WELWYN HATFIELD BOROUGH COUNCIL – DEVELOPMENT MANAGEMENT
DELEGATED REPORT

APPLICATION No: S6/2013/2225/FP

SITE ADDRESS: The Warren, 8 Carbone Hill

DESCRIPTION OF DEVELOPMENT: Extensions and alterations to existing dwelling to include front and rear two storey extensions and first floor balcony

Ground & First Floors
 Proposed Floor Plans Layout

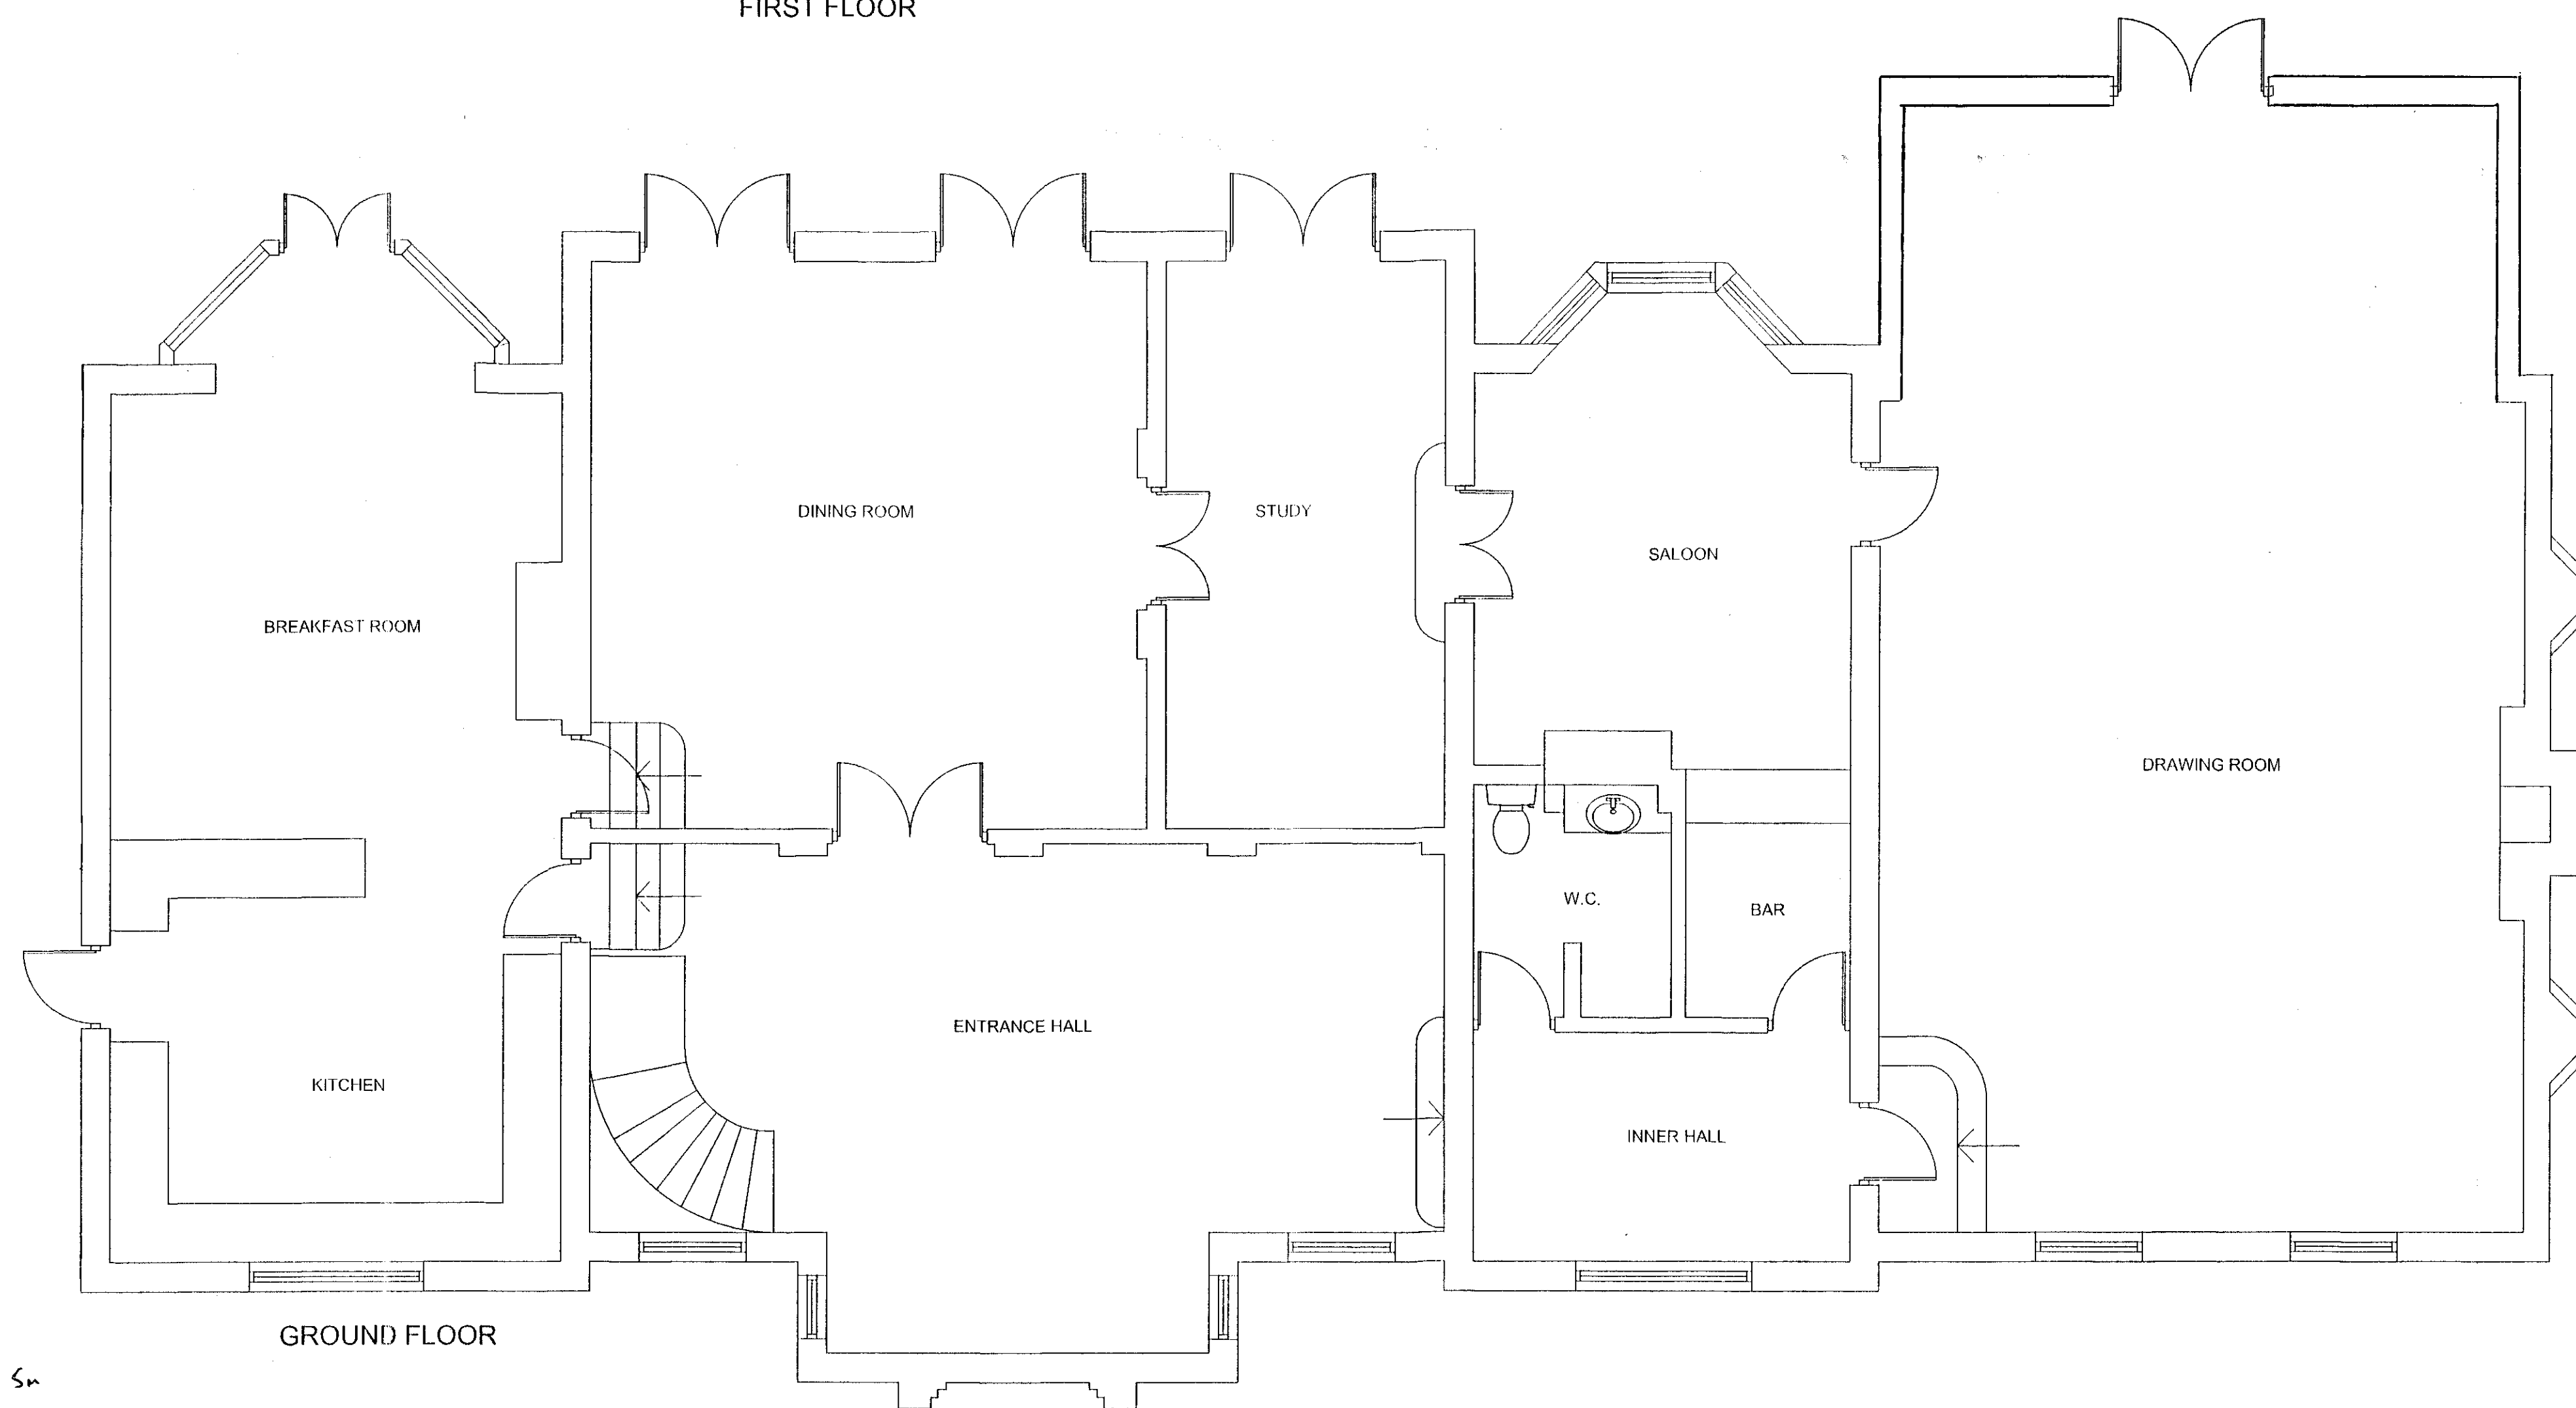
The main bulk of the proposed extensions would be added to the front of the building and to the roof where it is proposed to infill the area between the two existing projecting gables with the addition of a third gable feature. It is also proposed to square off the south west corner of the building with a two storey extension which would add a second gable to the flank elevation and increase the depth of the flank wall from approximately 4.5m to 8.9m at first floor level.

TITLE
Ground & First Floors
Proposed Elevations Layout

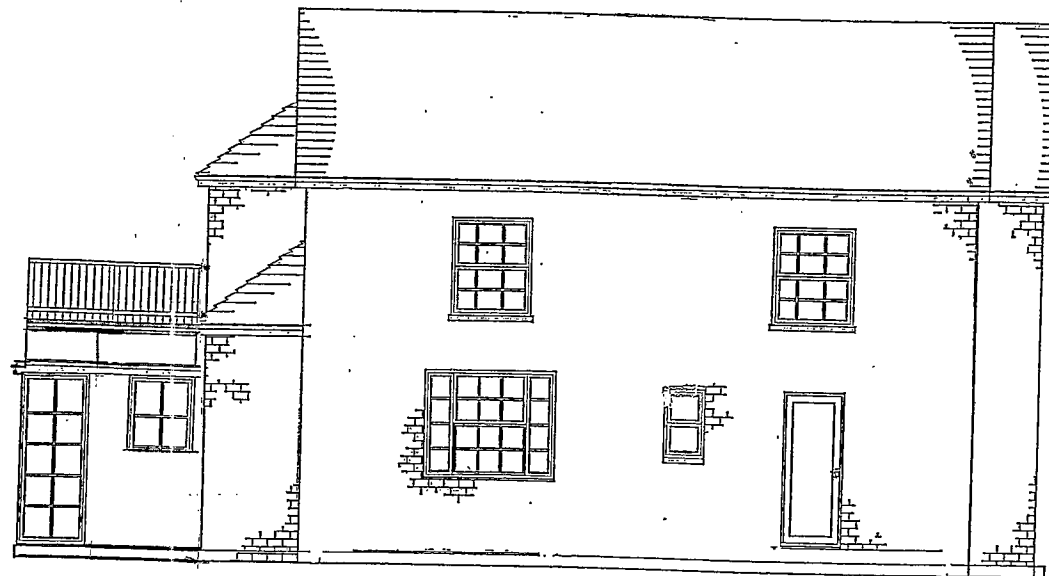
A large flat crown is proposed to limit the height of the extended roof to that of the existing ridge. The Supplementary Design Guidance states that *“extensions should be designed to complement and reflect the design and character of the dwelling and be subordinate in scale”*. The proposal would result in a substantial increase in the size of the application dwelling and is not be considered appropriately subordinate in scale. The fact that the proposed extension would have a large flat crown is symptomatic of an very large extension where the footprint is either too deep or too wide to accommodate a pitched roof without it having an excessively tall ridge.
